Our ref: HA/2021/122947/01-L01
Your ref: WA/106/20/DOC
Date: 24 February 2021

APPROVAL OF DETAILS RESERVED BY CONDITION IMPOSED UNDER REF WA/22/15/OUT RELATING TO CONDITION NOS 6 - MATERIALS & FINISHES, 10 - HARD & SOFT LANDSCAPING, 11(A) - PROTECTION OF RETAINED TREES, 12 - SURFACE WATER DRAINAGE, 14 - MAINTENANCE & MANAGERMENTS OF SUDS, 15 - FOUL DRAINAGE AND 20(D) - FORECOURT LAYOUT, DRAINAGE, POSITION & INTENSITY OF LIGHTING FITMENT

LAND TO THE EAST OF FONTWELL AVENUE FONTWELL

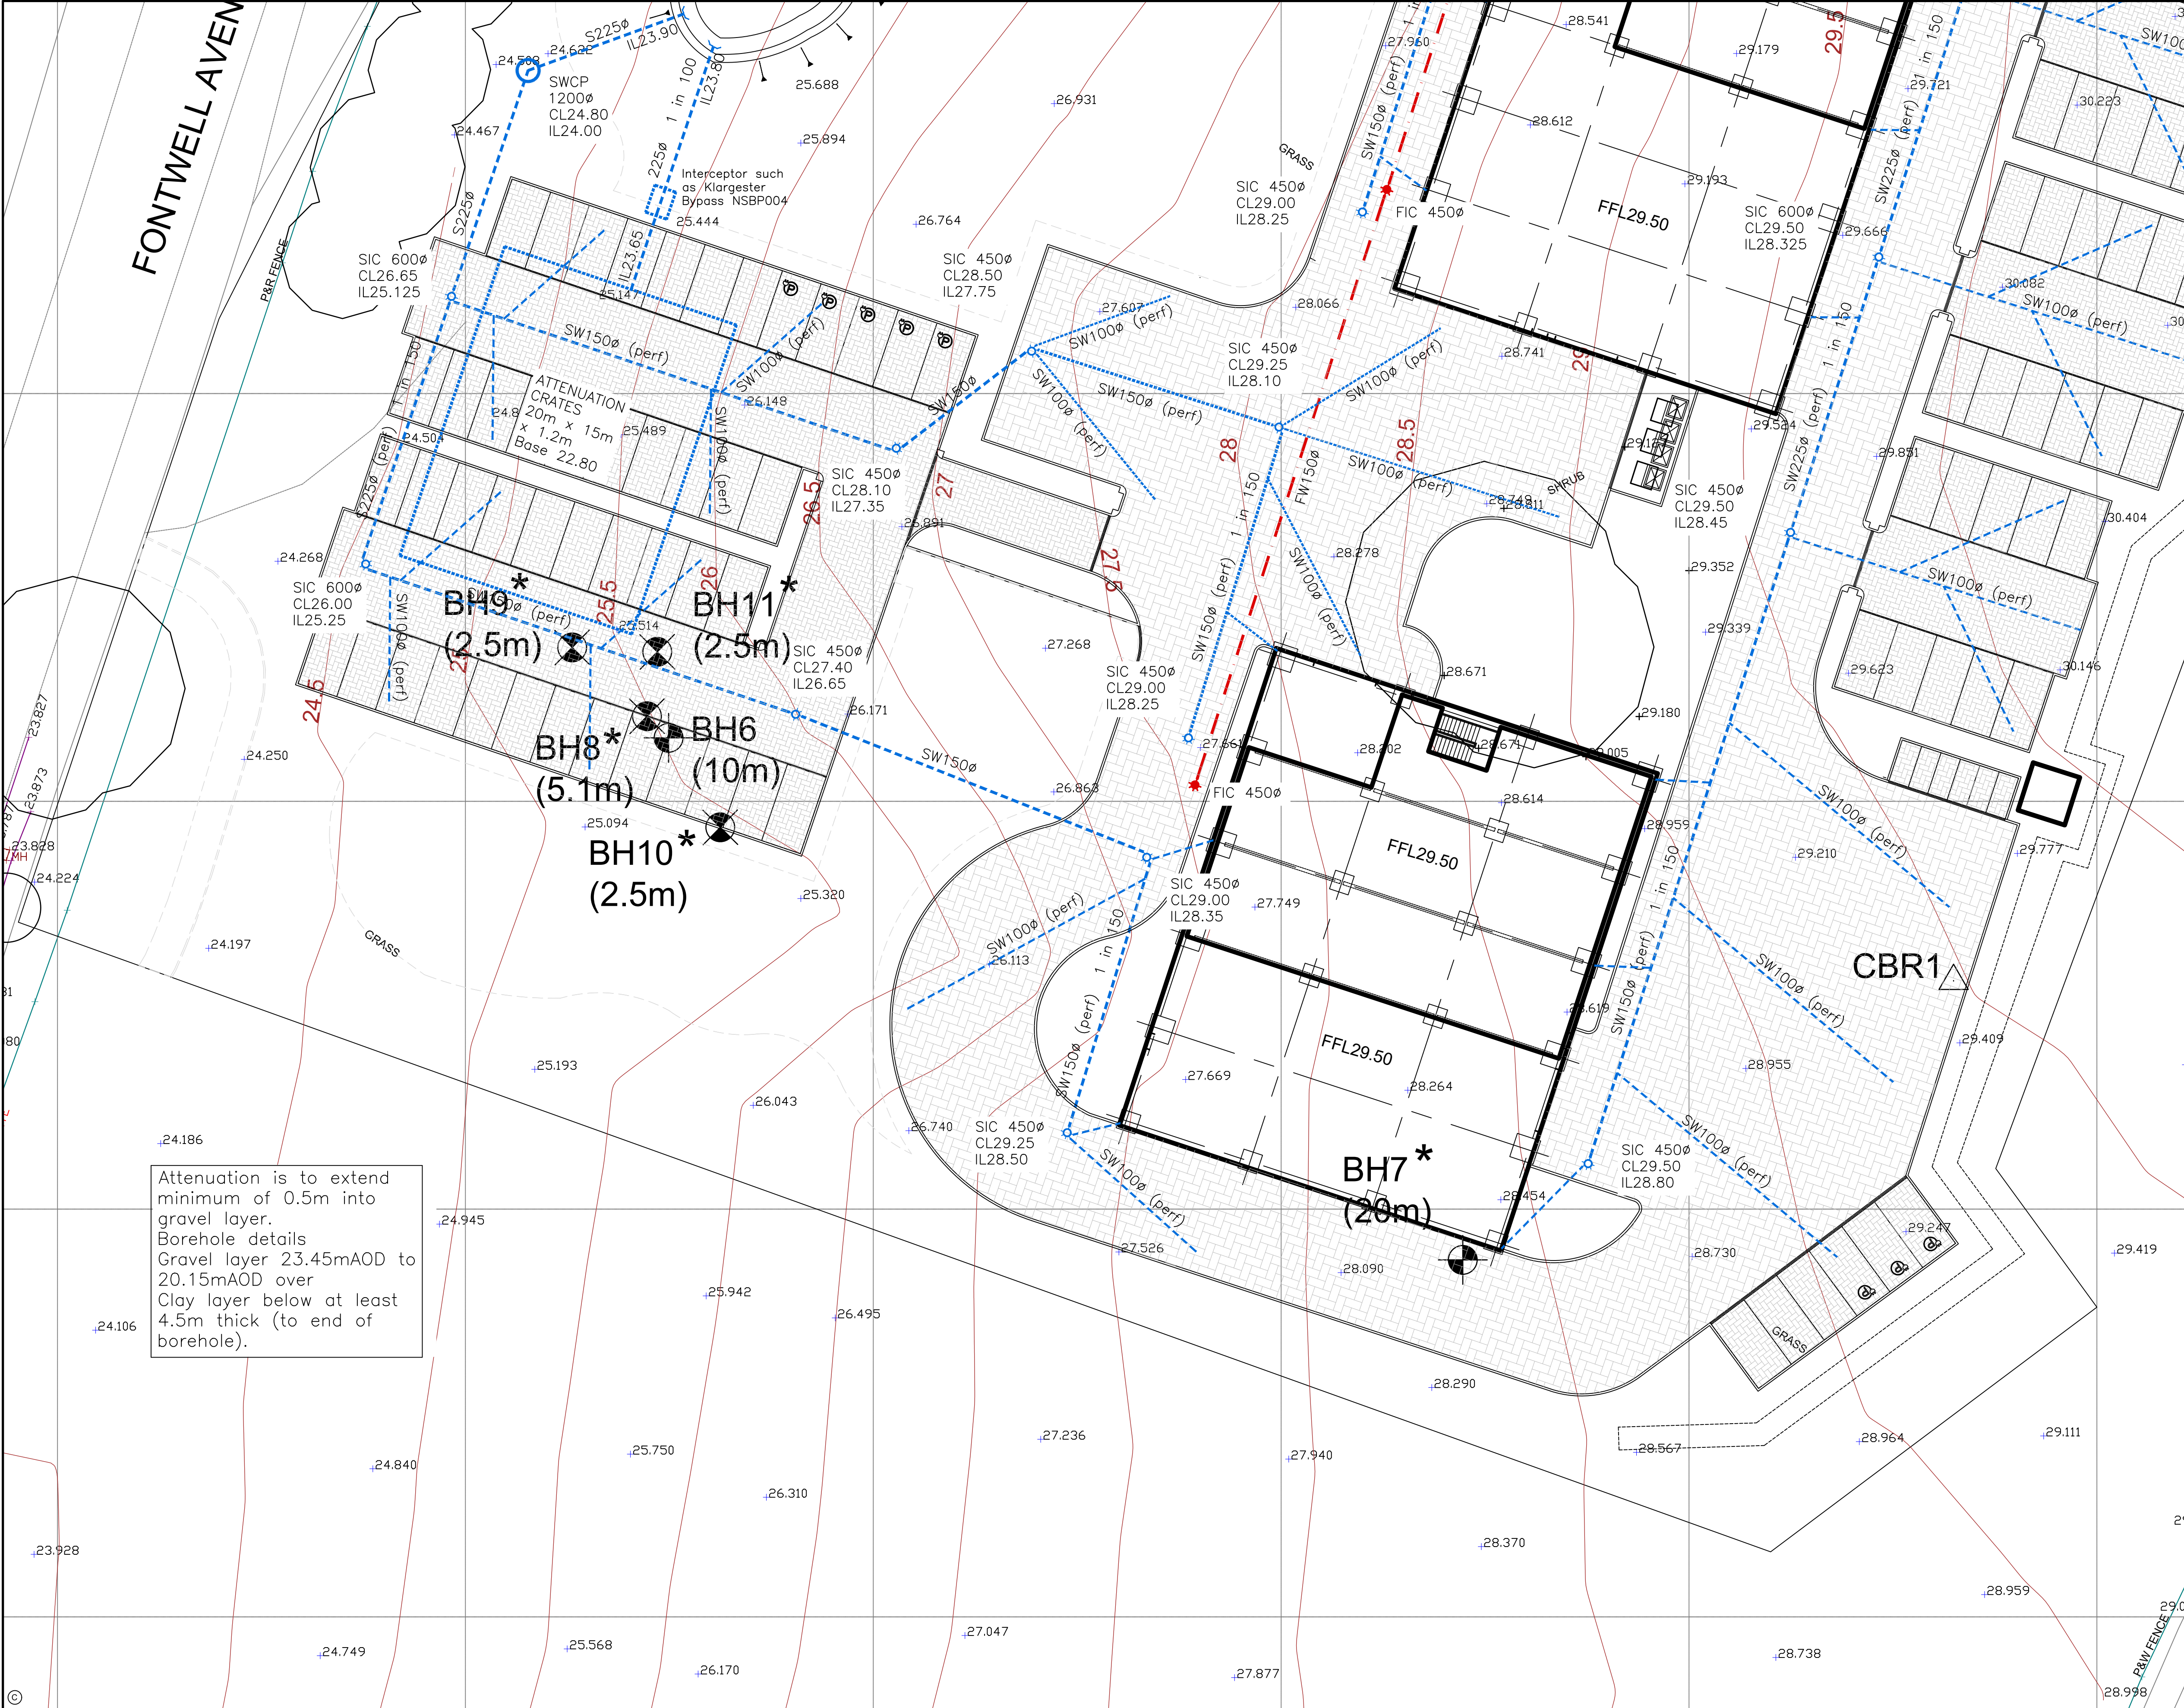
Condition 12 – Surface Water Drainage

We **are not able to** recommend the discharge of this condition. We require a detailed drainage strategy to be submitted which outlines the pollution prevention measures to protect groundwater with reference to the CIRIA SuDS manual C753.

In addition a detailed CEMP is required addressing the management of surface water during construction works and mitigation measures to be carried out to prevent pollution of controlled waters. We have read the Construction Management Plan (RA/01/GTR/CMP-3) however no mention of surface water is made in this report.

This development is in a location where groundwater is very sensitive to contamination as it is within a source protection zone 1 for Portsmouth Waters public water supply abstraction.
